Network Rail Consultation Response

To:	Arun District Council
Date:	17-May-22
Application reference:	BN/11/22/OUT
Location:	Barnham, Eastergate, Westergate BEW Parcel SC1 Barnham
NR Position:	More information required

SECTION A-A
SCALE 1:100

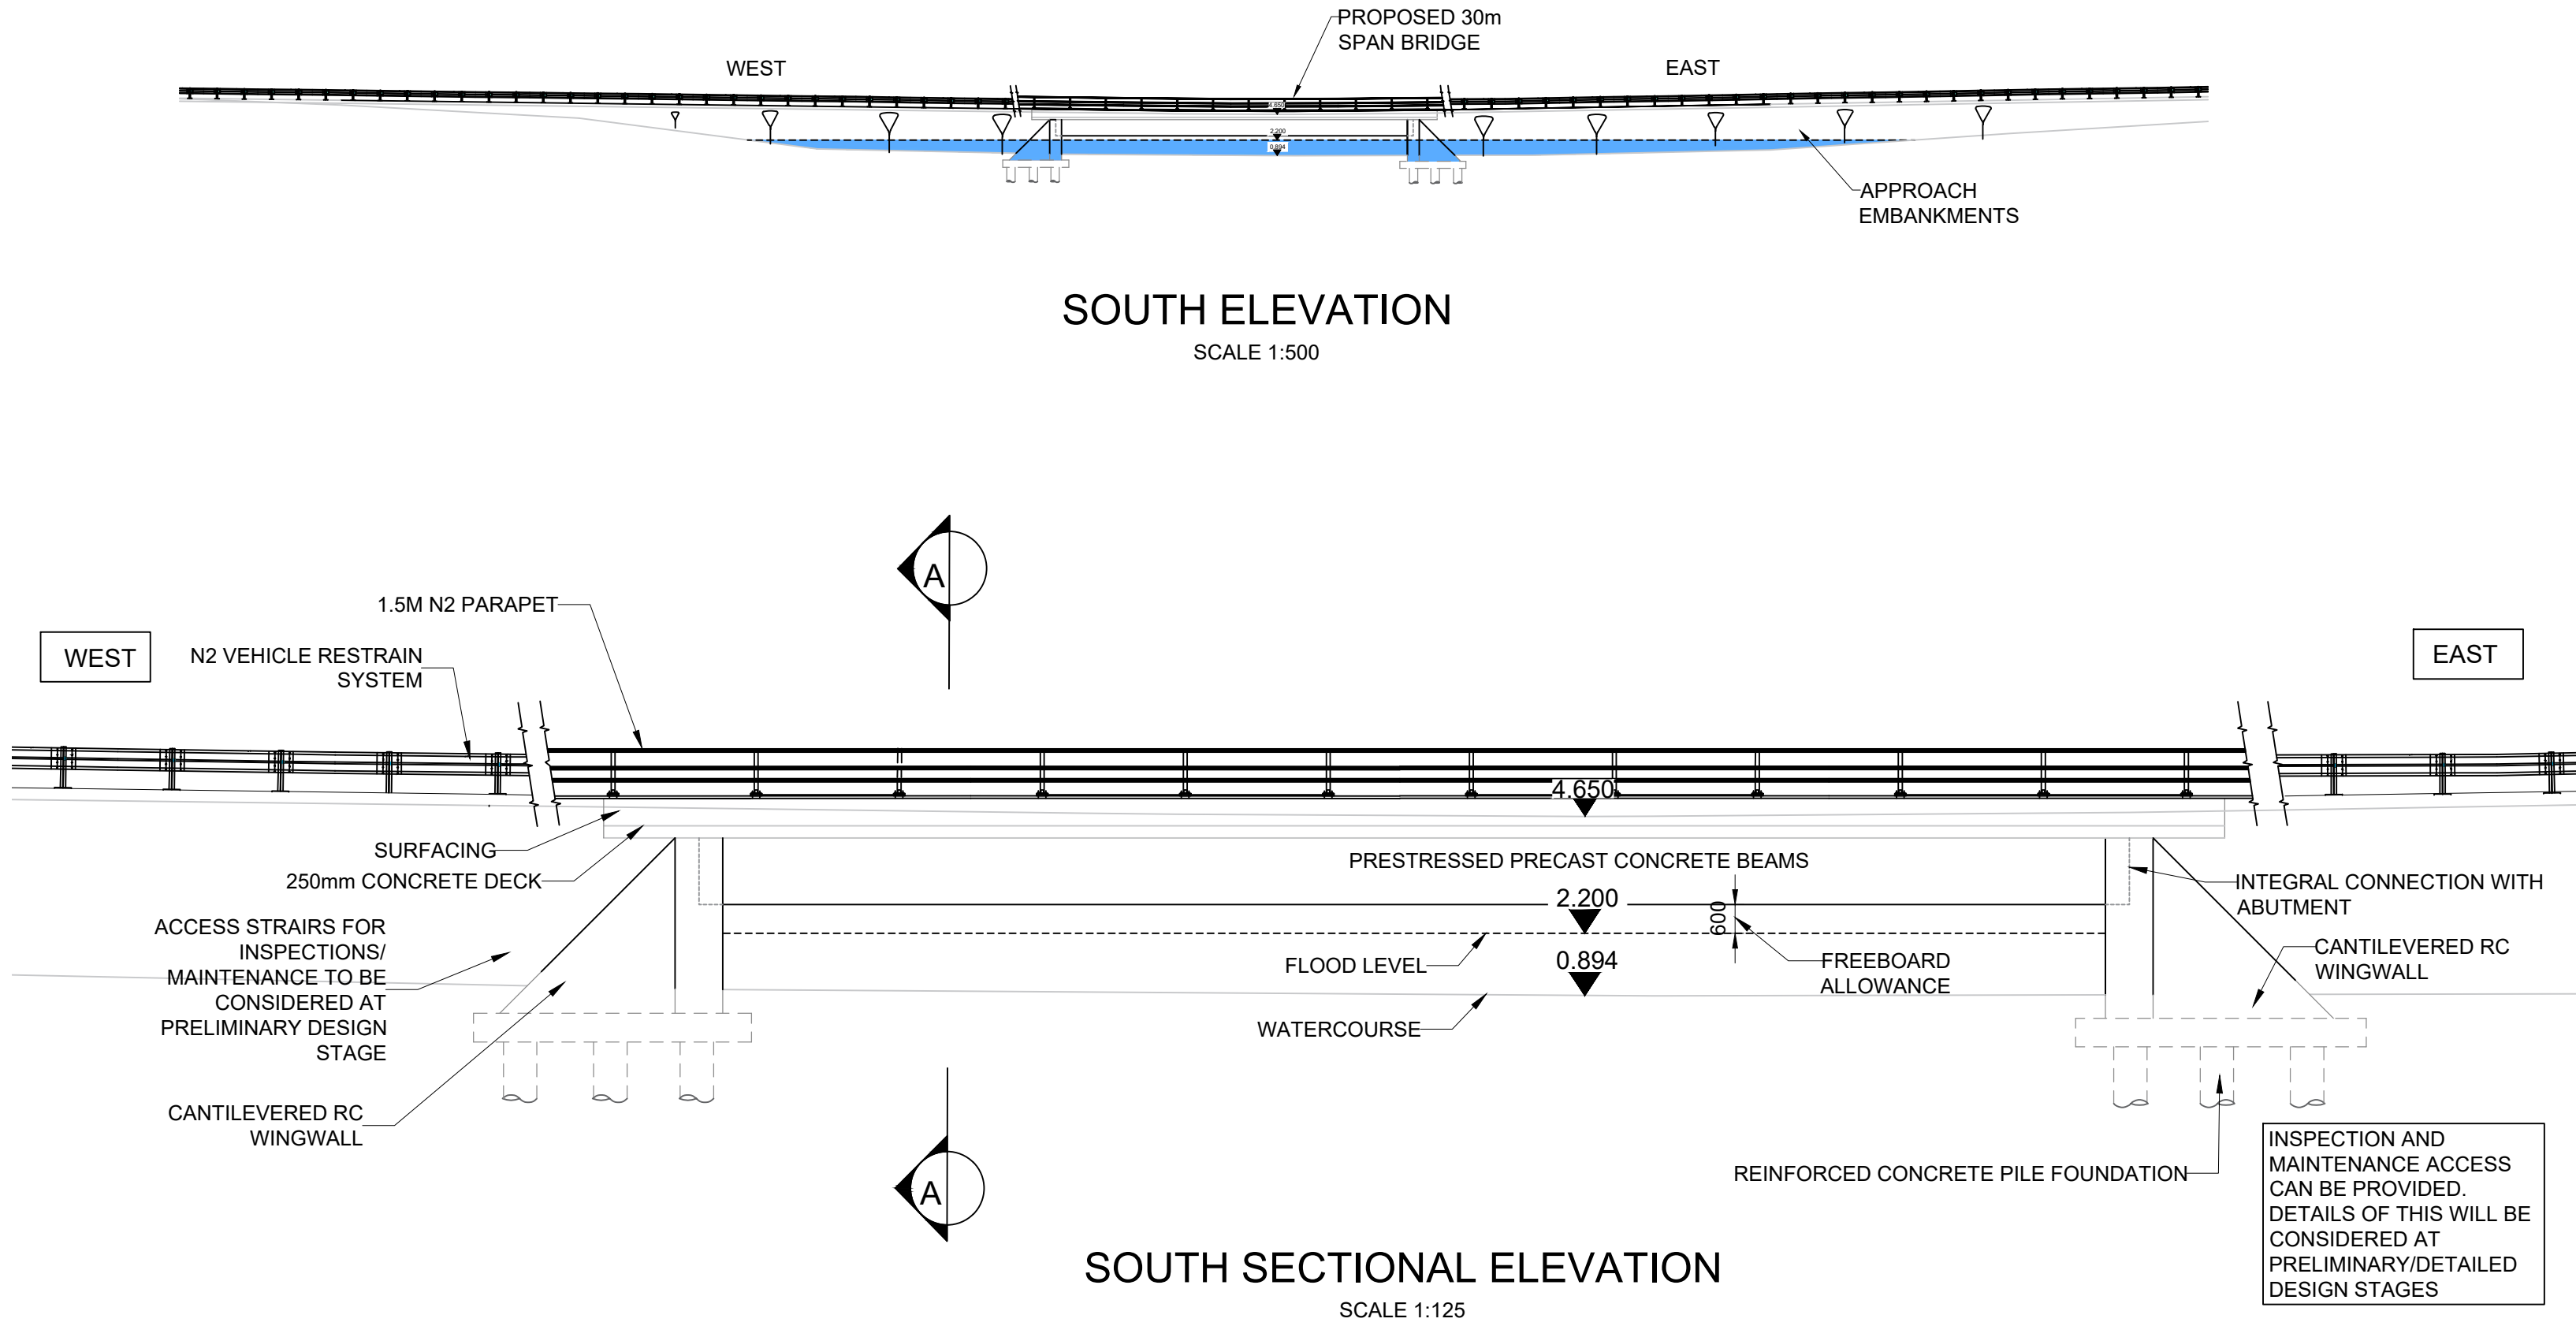
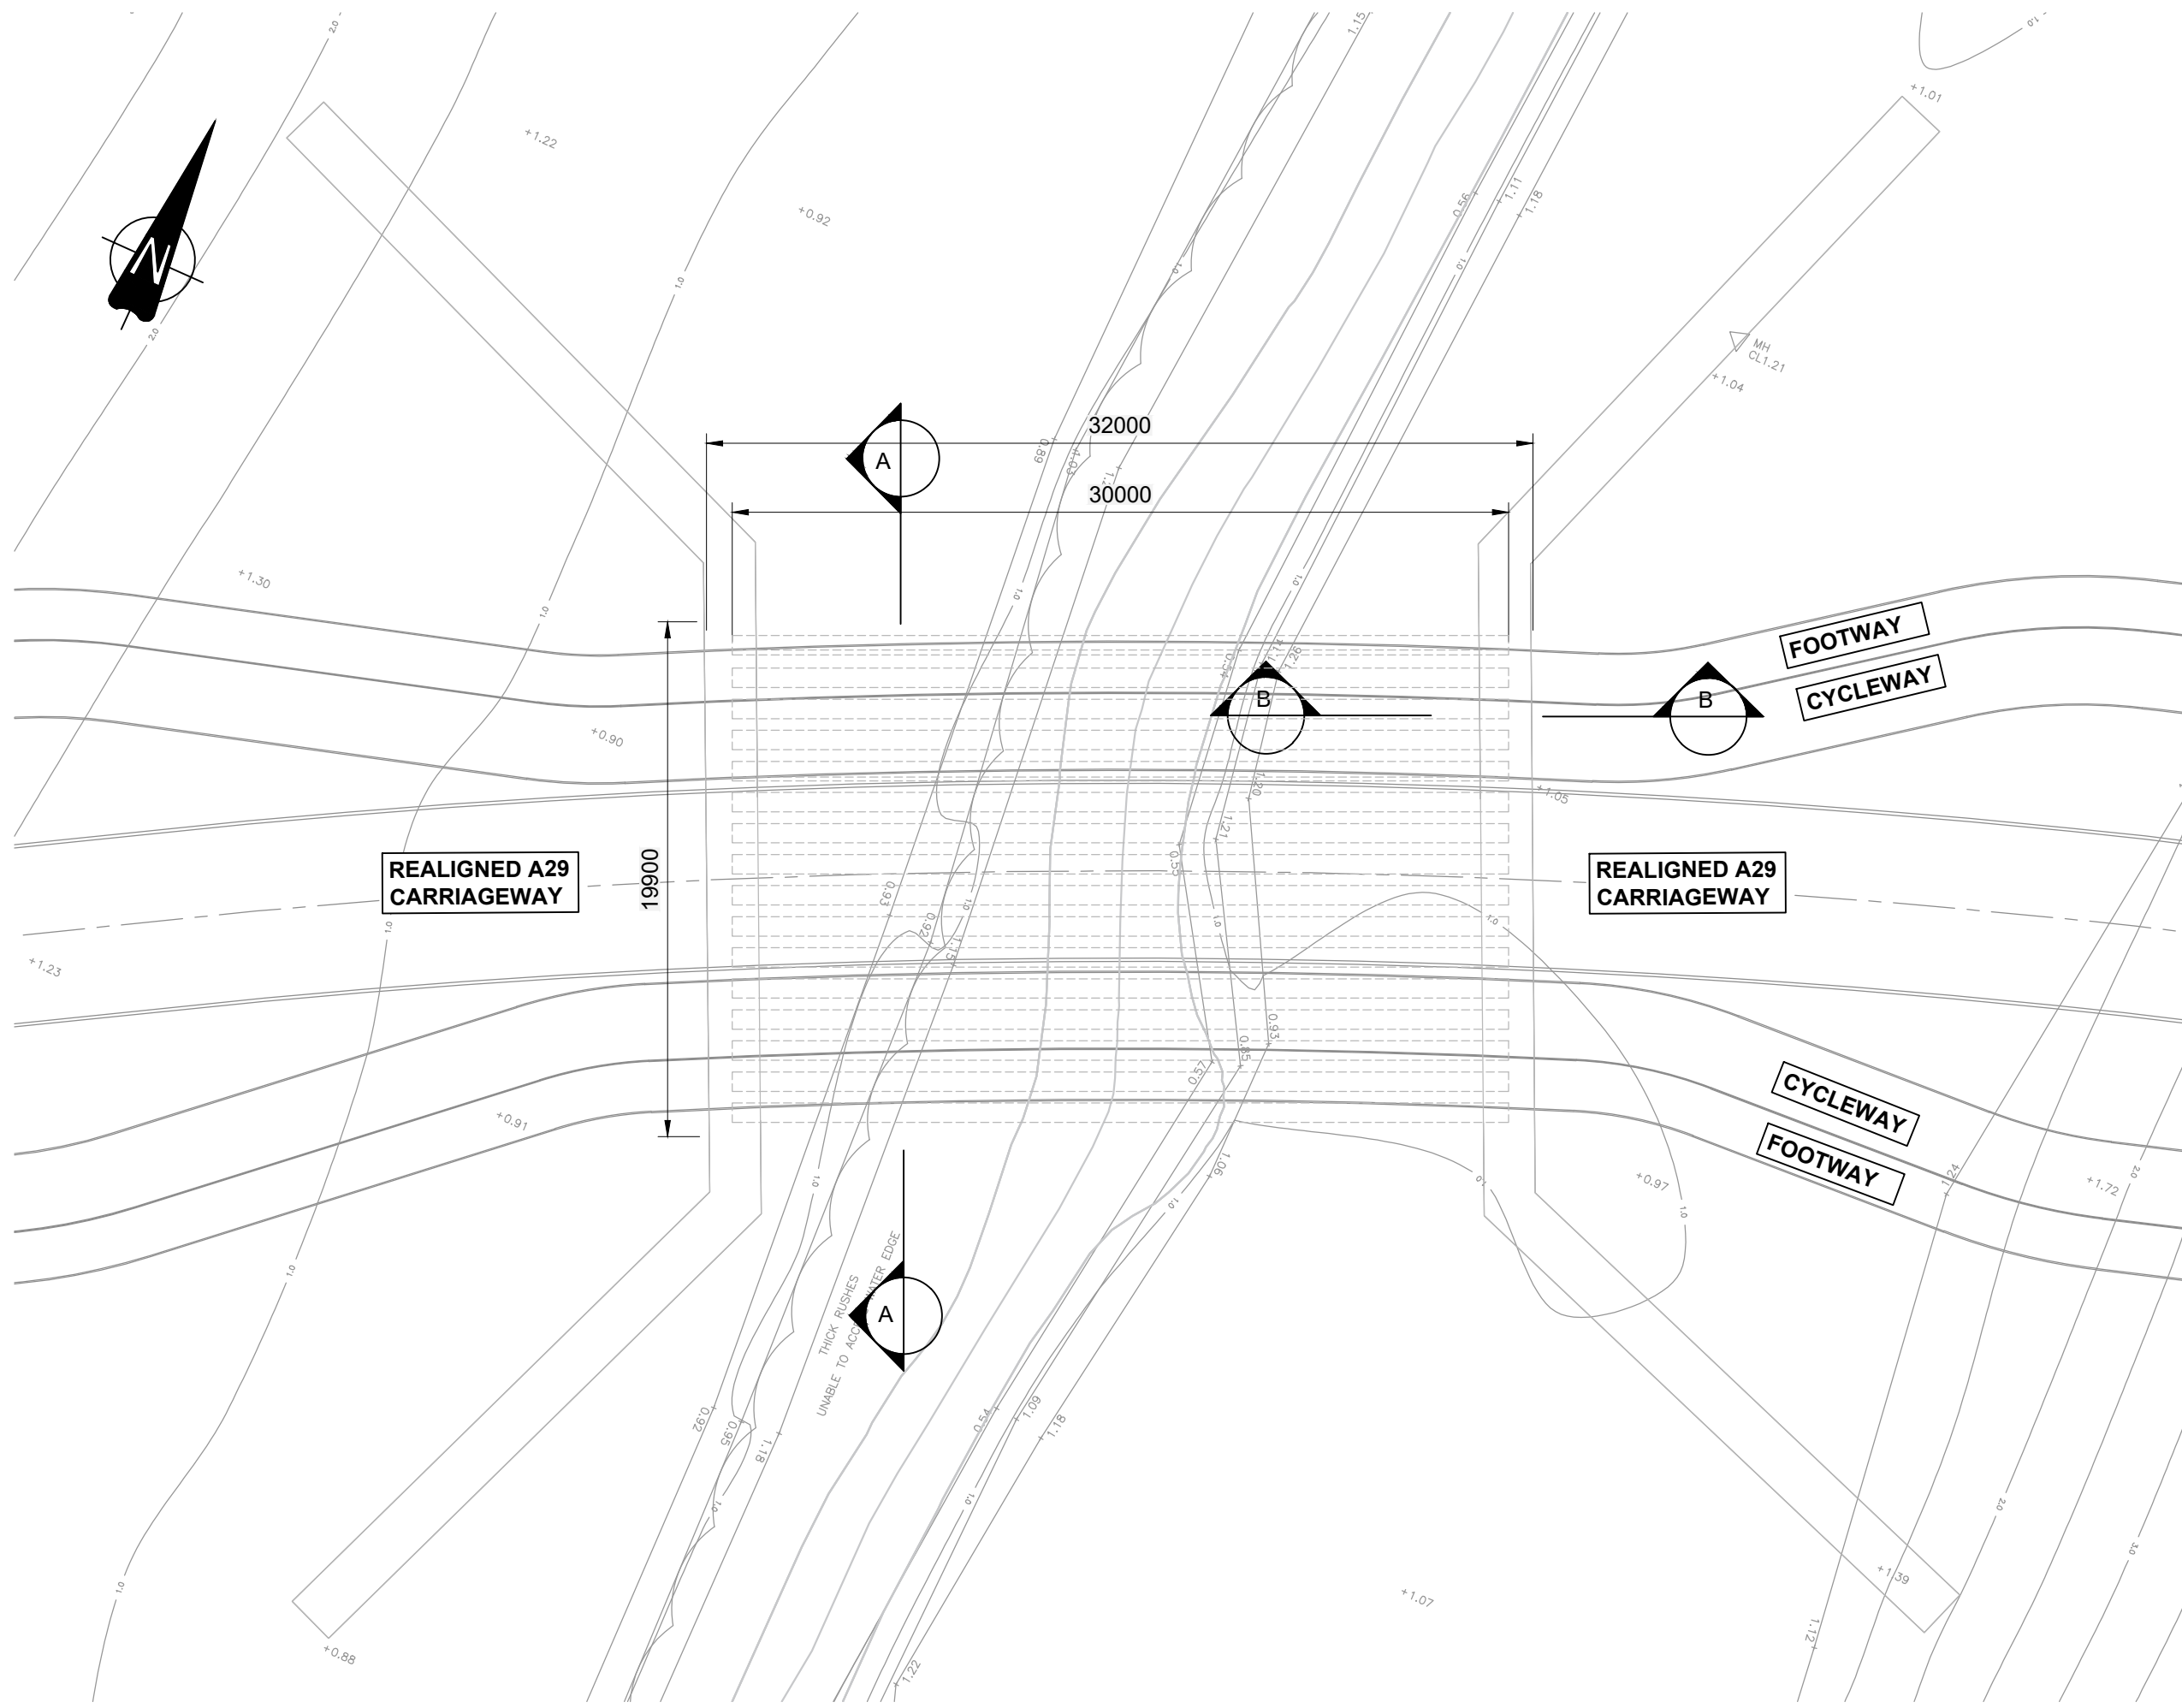
Each of the points raised above for the residential drainage are also pertinent for the link road drainage. We note that there is no proposed drainage over the track/Network Rail boundary, with a system of pipes and gullies taking runoff from both ramps north and south respectively. We have a network of track drainage here with some earthwork's drainage in the vicinity so we will need to ensure that the construction of any bridge over NR land has no detrimental impact on our assets.
